COMMUNITY DEVELOPMENT DEPARTMENT
 80 Columbia Avenue ♦ Marysville, WA 98270
 (360) 363-8100 ♦ (360) 651-5099 FAX

June 2, 2022

Re: Brodie Subdivision – Pre-Application - PreA22-026

LAND PRO GROUP, INC.
BRODIE PLAT
EXISTING CONDITIONS MAP

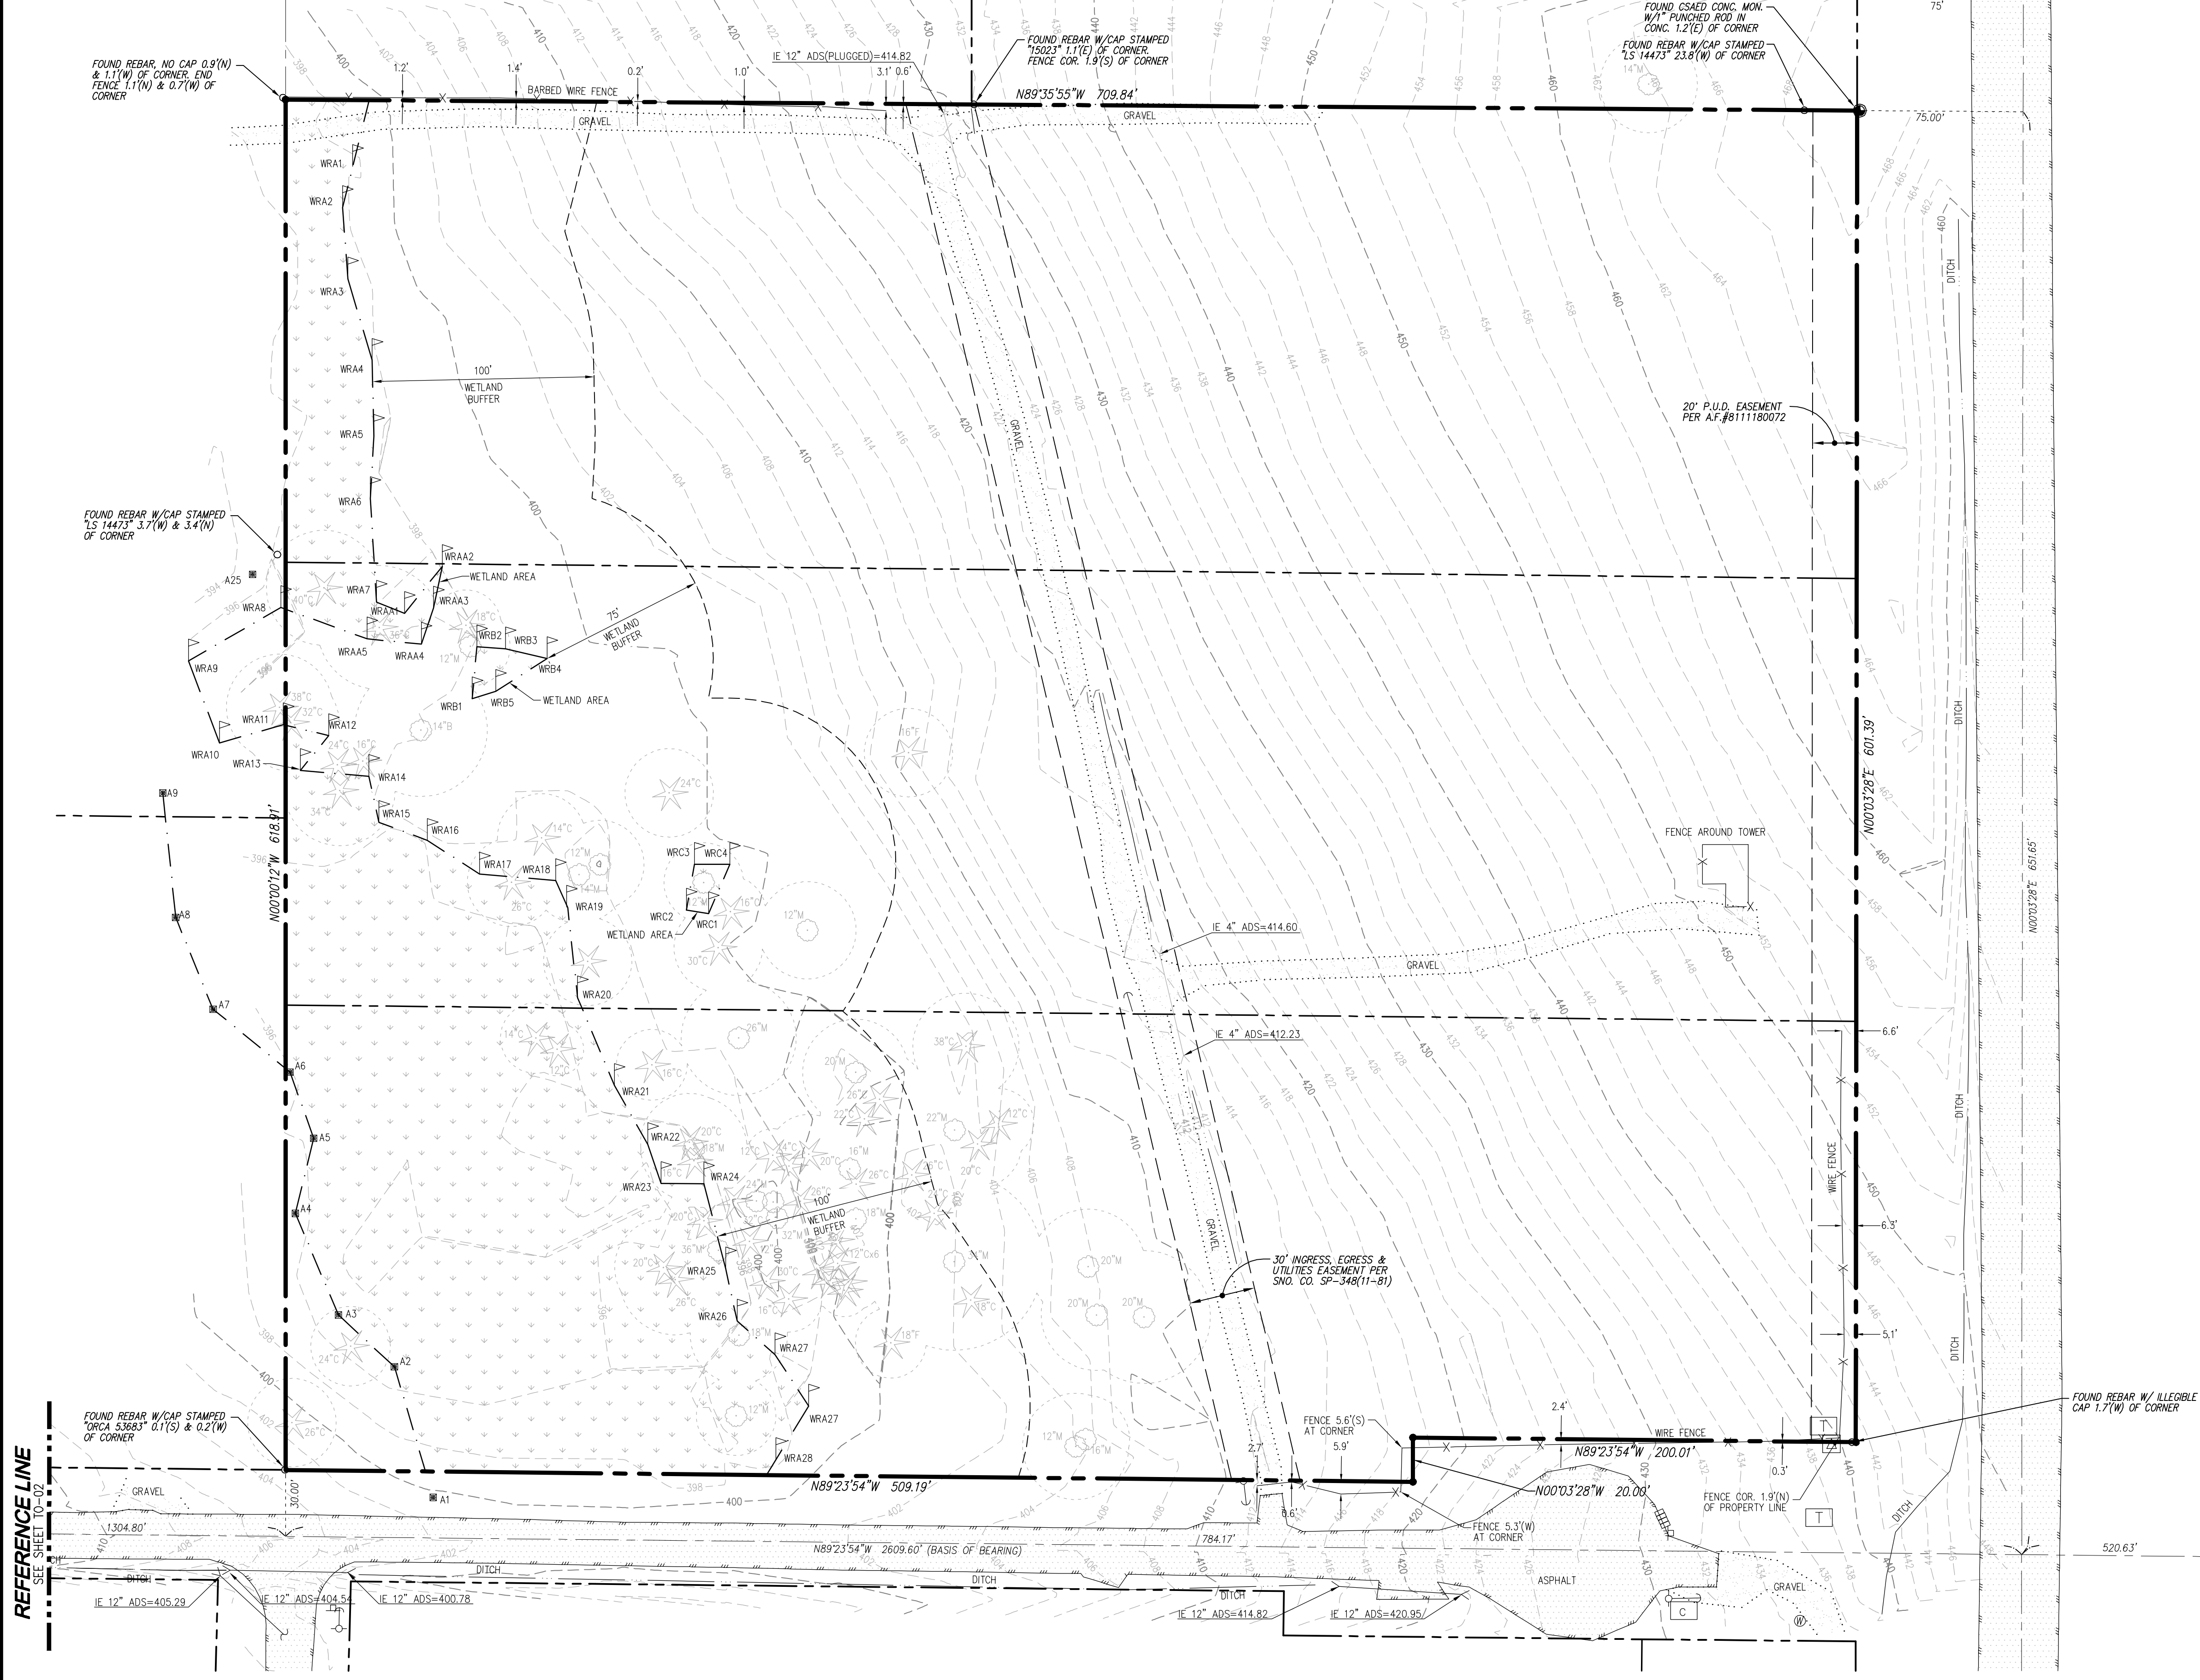
10. The site plan indicates retaining walls along the eastern property line. Per MMC [22D.050.030\(5\)](#), if retaining walls taller than 4 ft. are used, as measured from the average grade, and are visible

from the street or adjacent property, they shall be terraced so that no individual segment is taller than 4 ft. Terraced walls shall be separated by a landscaping bed at least 2 ft. in width.

Alternative landscaping treatments may be considered, provided they reduce the bulk and scale of the retaining wall and enhance the streetscape or transition between properties. Being as this eastern property line abuts to SR 9, the project is subject to landscaping buffer requirements of [MMC 22C.120.150](#); therefore, this section could remedy the above retaining wall requirements.
